Lead Local Flood Authority
Post Point CHN 215
Hertfordshire County Council
County Hall, Pegs Lane
HERTFORD SG13 8DN

Date 19 March 2020

RE: 6/2019/3024/MAJ – 29 Broadwater Road, Welwyn Garden City, AL7 3BQ

David Uncle
SuDS Officer
Environmental Resource Planning

Status					
PLANNING					
Project No.	Zone	Level	Role	Drawing No.	Revision
C12885	ZZ	XX	C	0001	P1
Scale	Drawn	Chkd	Passed	Date	Size
1:200	CC	-	-	19.08.19	A1

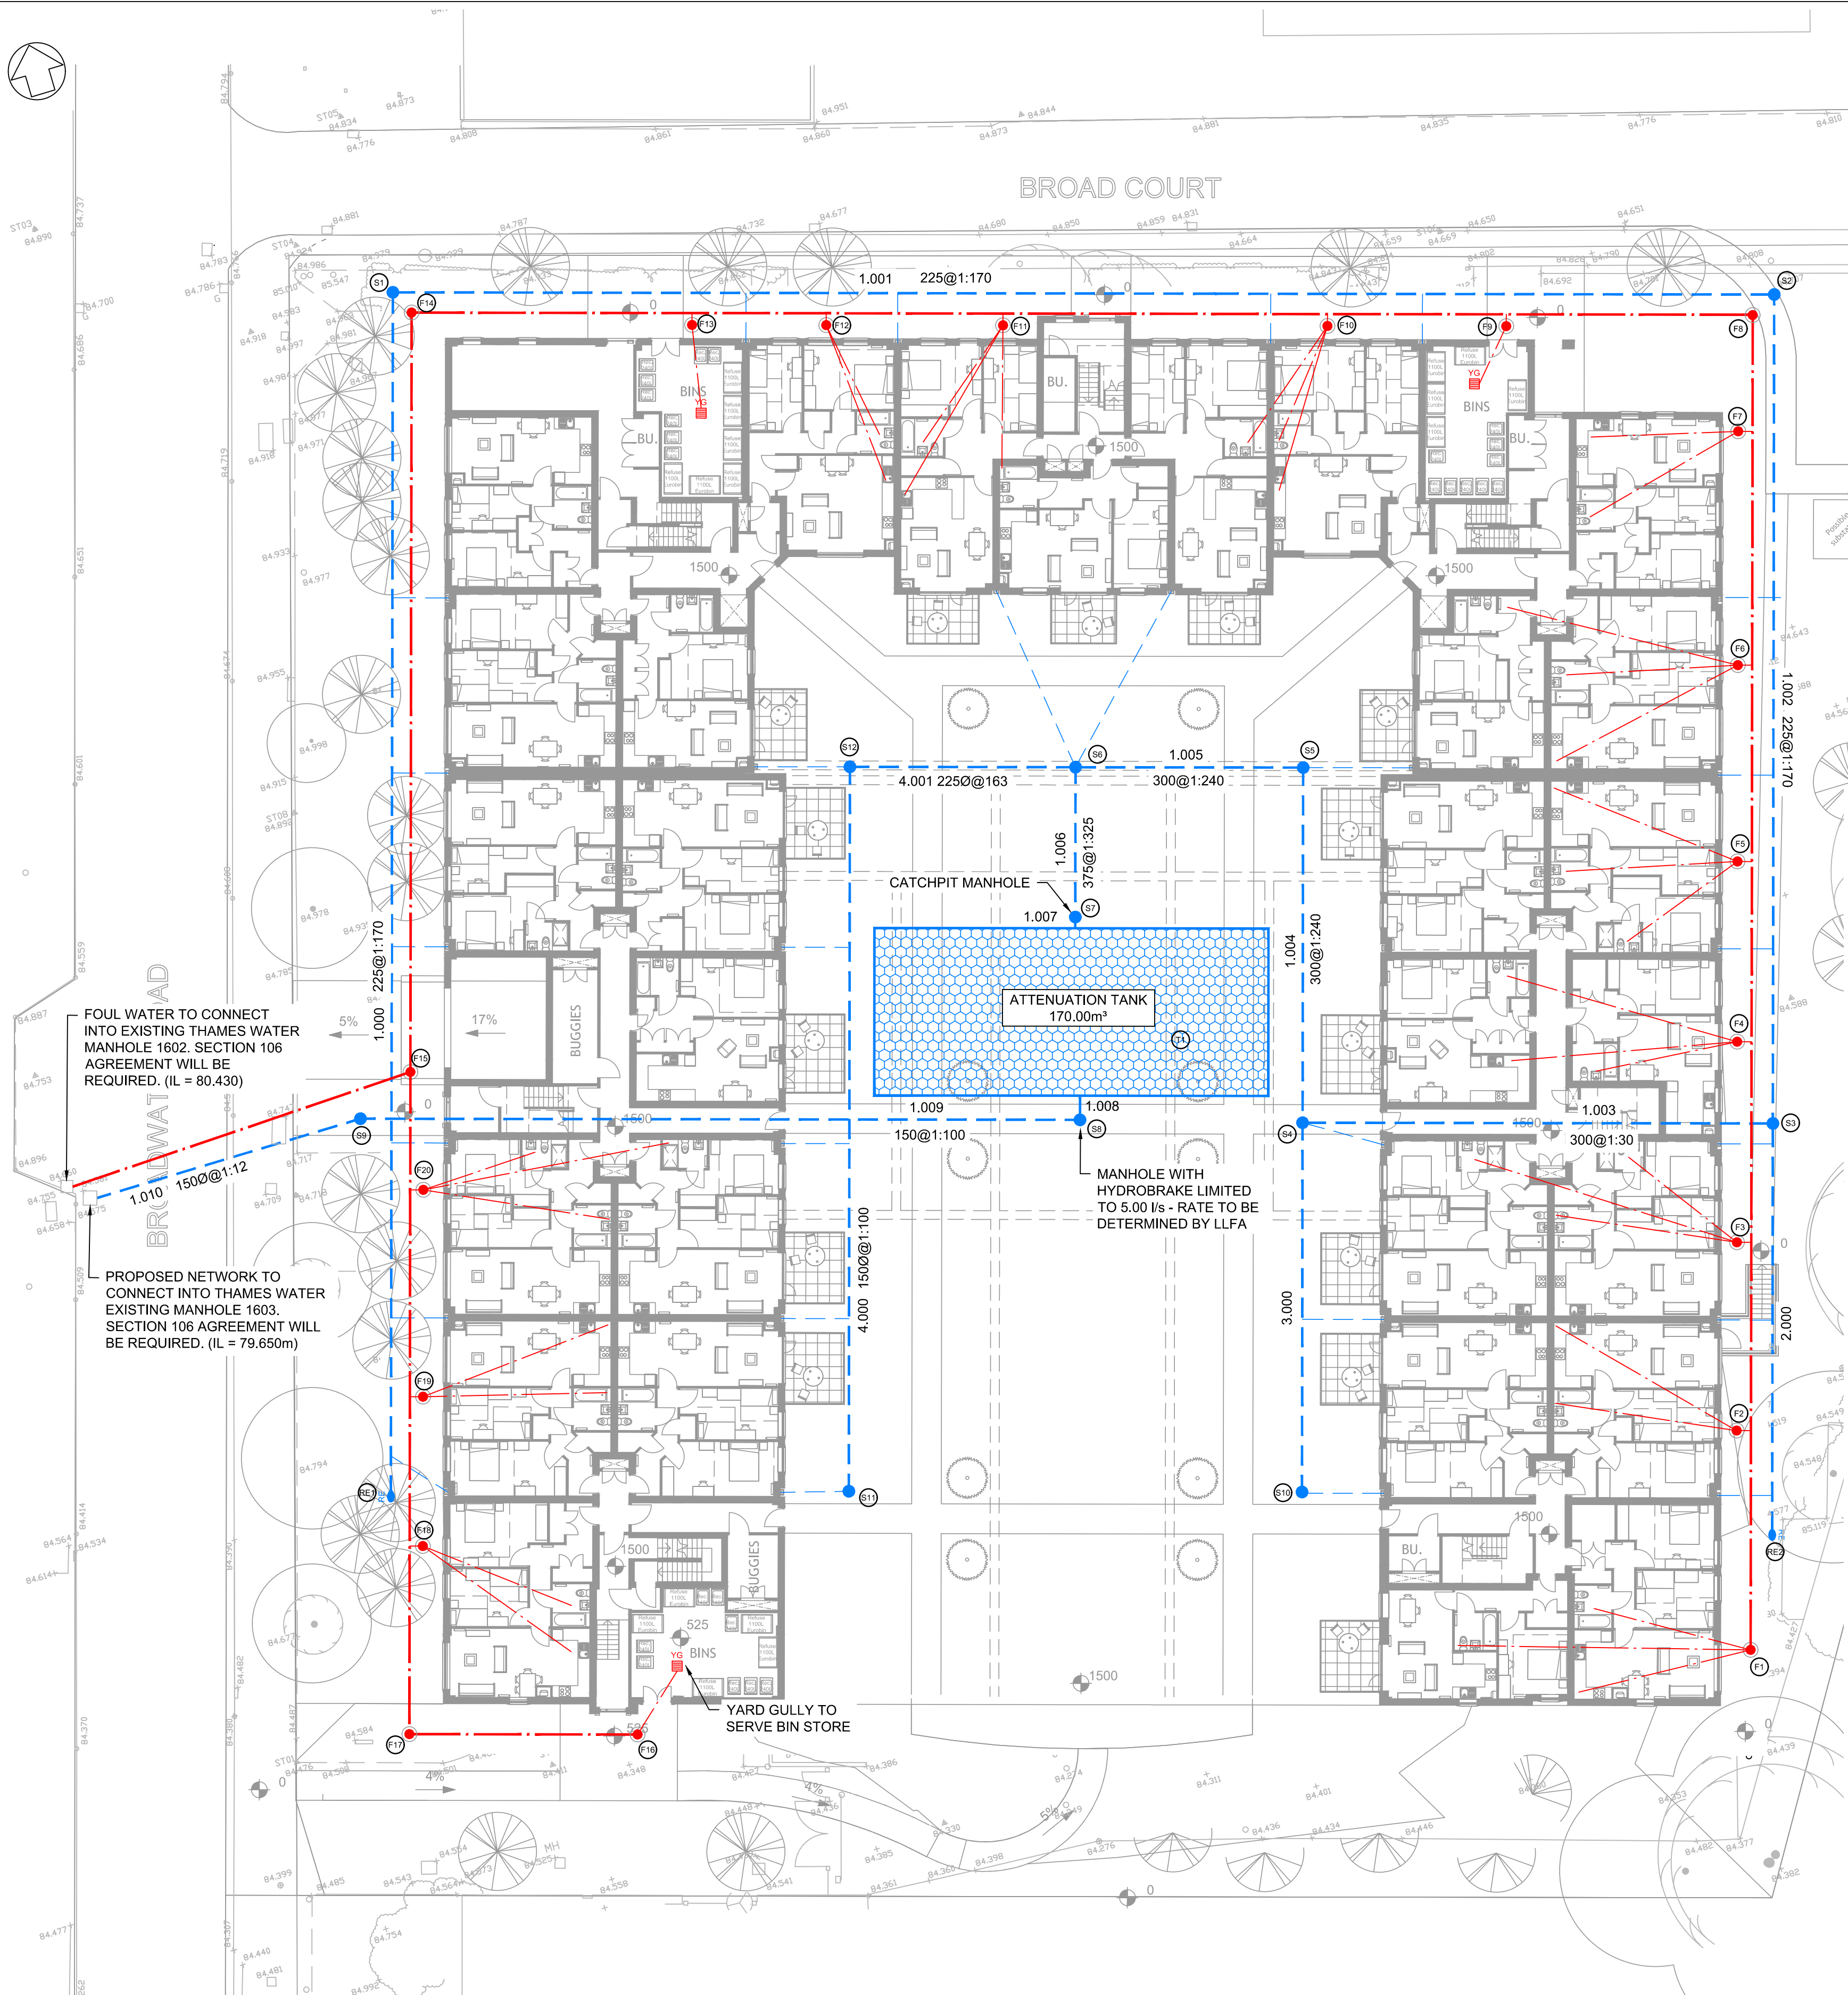
We understand it is proposed to use an attenuation tank comprising approximately 170m³ of storage before discharge to Thames Water surface water sewer at a restricted rate of 2l/s.

2. We understand that the applicant proposes to discharge to geocellular attenuation tank then to Thames Water surface water sewer.

We would consider attenuation tanks less sustainable in accordance with the SuDS hierarchy. The applicant should explore the use of above-ground SuDS features in order to provide additional benefits such as amenity and biodiversity. We require robust justification explaining why above-ground SuDS cannot be implemented on site.

3. We acknowledge that smart sponges on the outfalls from downpipes from the roofs, podium and car park are proposed. We are pleased that a green roof is proposed for the podium deck.

However, we do not consider smart sponges as SuDS management and treatment stages. The applicant should include at least two SuDS management and treatment stages on the site to provide a level of treatment to runoff. We understand that green roofs may be proposed, therefore these areas should be indicated on the drainage strategy. SuDS management and treatment should also be provided for all runoff generated on site including the basement car park.

We note that lined permeable paving could be utilised for the parking areas and above-ground features may be feasible elsewhere on site to provide further treatment.
